## Quality Review Form

Project Name: Northern Monument Creek Interceptor

Work Product: SWPPP

**Reviewers**  
El Paso County

**GENERAL  
GENERAL LEGEND**

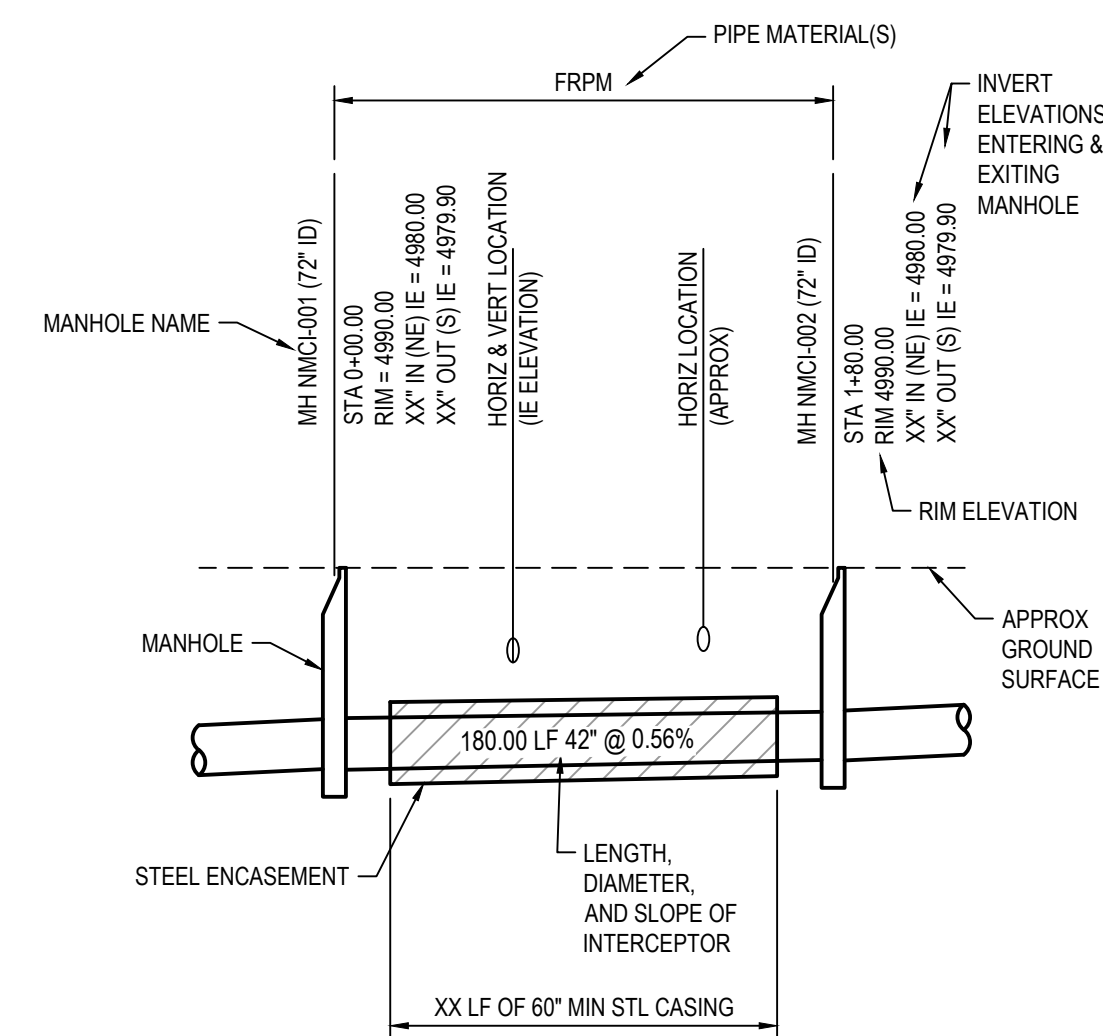
4	Glenn Reese			ESQCP Form	Go ahead and sign.	Form has been signed.	5/1/2026	R Keatley	
5	Glenn Reese			FAE	Shouldn't this be 2.68ac to match LOD on plans?	Disturbed area contains both asphalt and trail removal/replacement which will not be seeded. Seeding has been rounded up to nearest whole number based on direction within spreadsheet.	5/8/2026	R Keatley	
6	Edward Schoenheit			FAE	Owner/Rep sign	Signature now added.	5/8/2026	R Keatley	
7	Glenn Reese			GEC, pg 1	Please add this text: EPC EDARP File No. CDR266	Added to cover page.	5/1/2026	R Keatley	
8	Edward Schoenheit			GEC, pg 2	Remove from all sheet prior to stamping and signing.	Filler text removed.	5/1/2026	R Keatley	
9	Glenn Reese			GEC, pg 5	GEC checklist item L. If "limits of disturbance" and "construction boundary" are the same, change to "limits of construction/disturbance" or otherwise show as separate line types for each on the legend and figure.	Line is the same, legend has been revised accordingly.	5/1/2026	R Keatley
